**Department of  
Primary Industries**

OUT12/20494

**Tasman Extension Project (SSD 4962)  
Response to exhibition of EIS**

### Tasman Extension Project (SSD 4962) - Response to exhibition of EIS

Figure 8: Panel Layout & Subsidence Control Zones

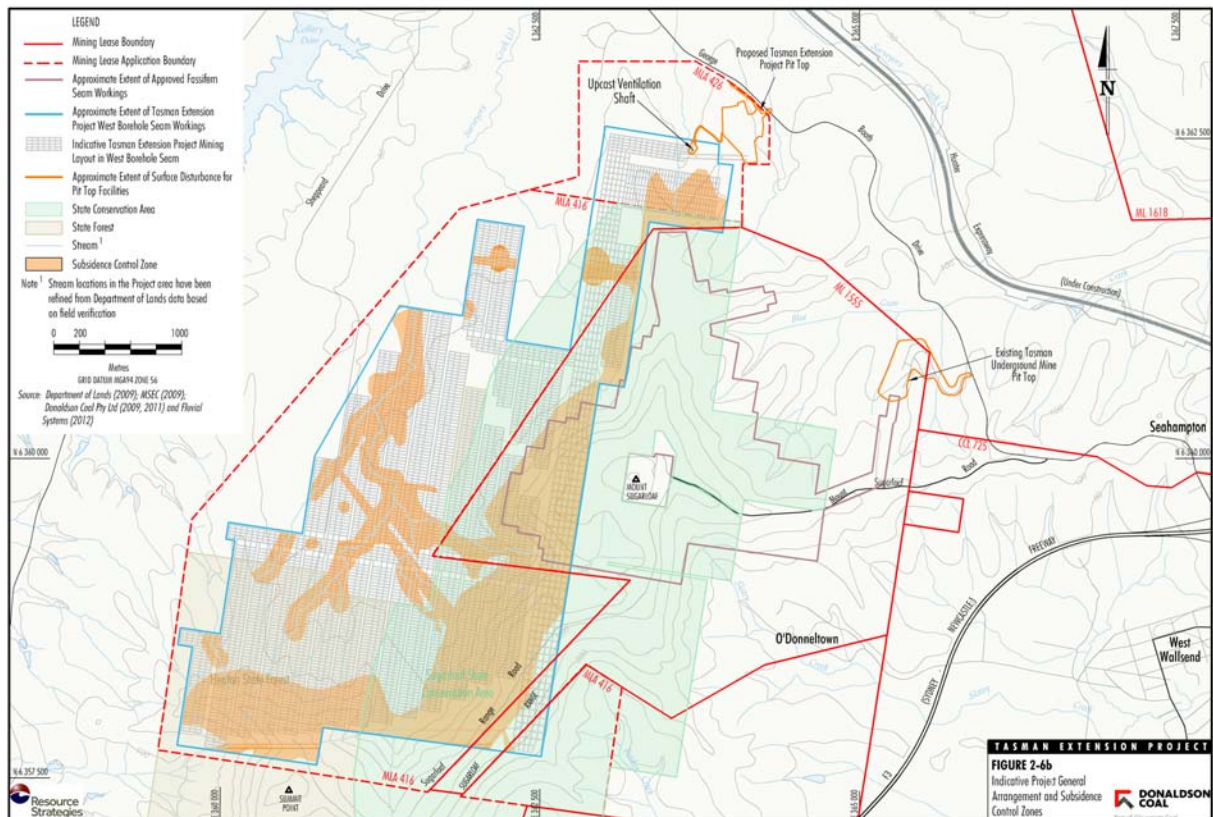
The EIS provides that subsidence related impacts will be managed by the adoption of 'subsidence control zones' around watercourses and groundwater dependent ecosystems (GDEs) to achieve nominated subsidence performance measures. If the proposed project is approved, the subsidence performance measures for watercourses and GDEs should be included in the conditions of approval. Further, as a precautionary approach, the Proponent should not commence mining under any watercourse until a stability assessment of the watercourse has been undertaken.

- The proponent shall ensure the proposed subsidence performance criteria as set out in the Environmental Impact Statement are achieved. Should actual subsidence deviate from predicted levels, the proponent shall undertake an investigation to determine the

causes of such deviation, and measures to ensure the Subsidence Control Zones do not experience subsidence above predicted levels.

- The Proponent shall not commence mining under any watercourse until a stability assessment of the watercourse has been conducted.
